Your Ref: AB/17/19/DOC

Town & Country Planning Act 1990 (as amended)
Town and Country Planning (Development Management Procedure) (England) Order 2015
Approval of details reserved by condition imposed under ref AB/99/18/L relating to Condition No 2
new joinery, Condition No 3 rainwater goods, Condition No 4 fire surround and Condition No 7
basement flooring.
44 Tarrant Street Arundel,,

Condition Number 2

Dwg No GFD1 Revn.

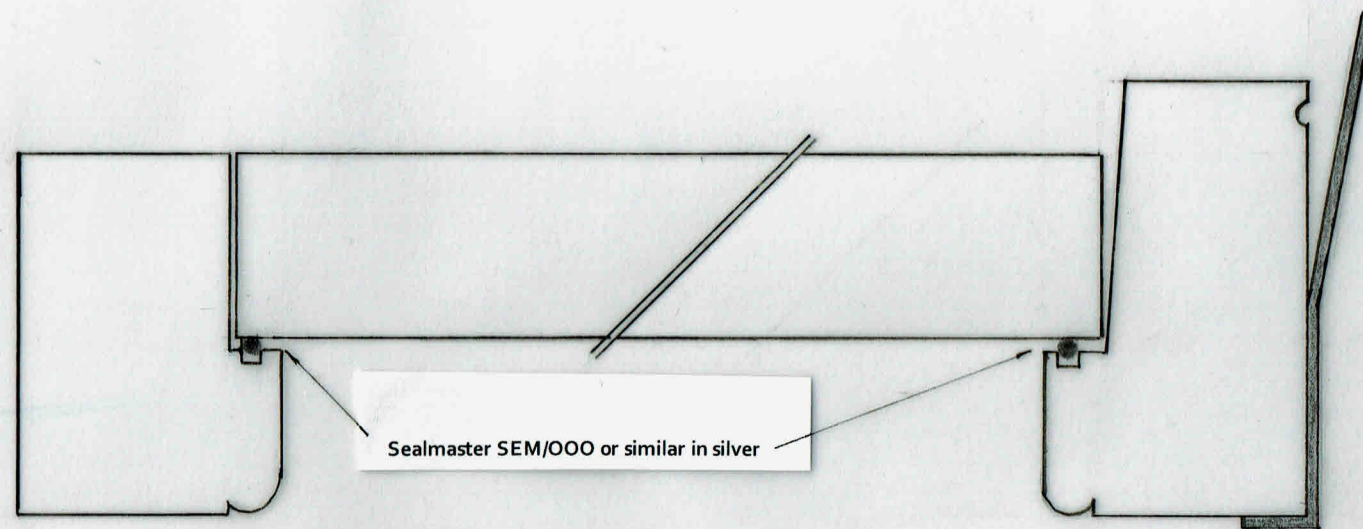
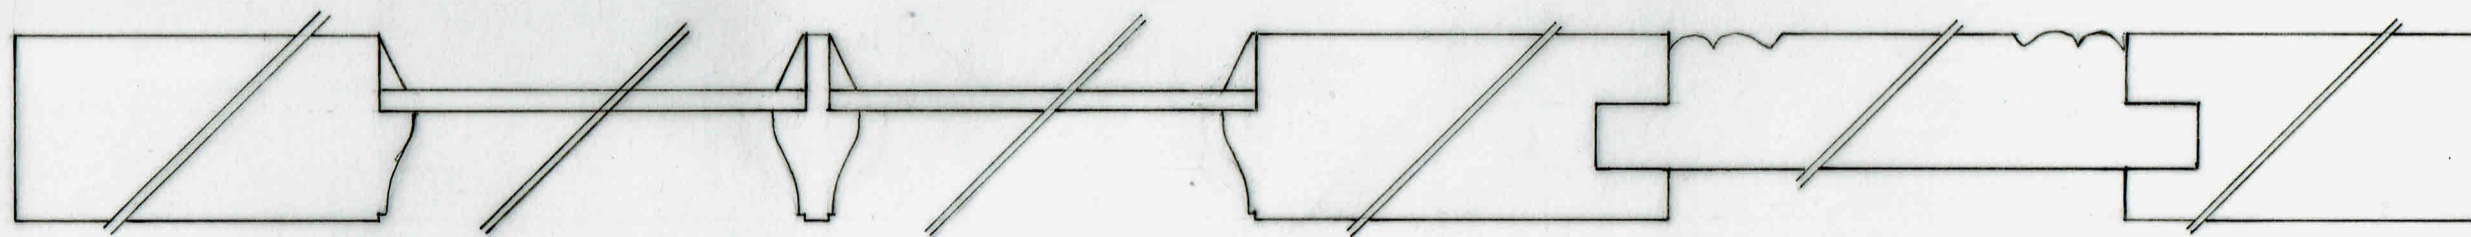
This condition is discharged in so far as submission of details relates and refers to the details indicated on drawings GFD1 and 114 which includes reference to some of the existing windows being repaired rather than replaced.

Reference is made that the measurements provided as part of this application have been taken from the existing windows which will ensure the windows will look exactly the same as they do now. Such an approach is supported.
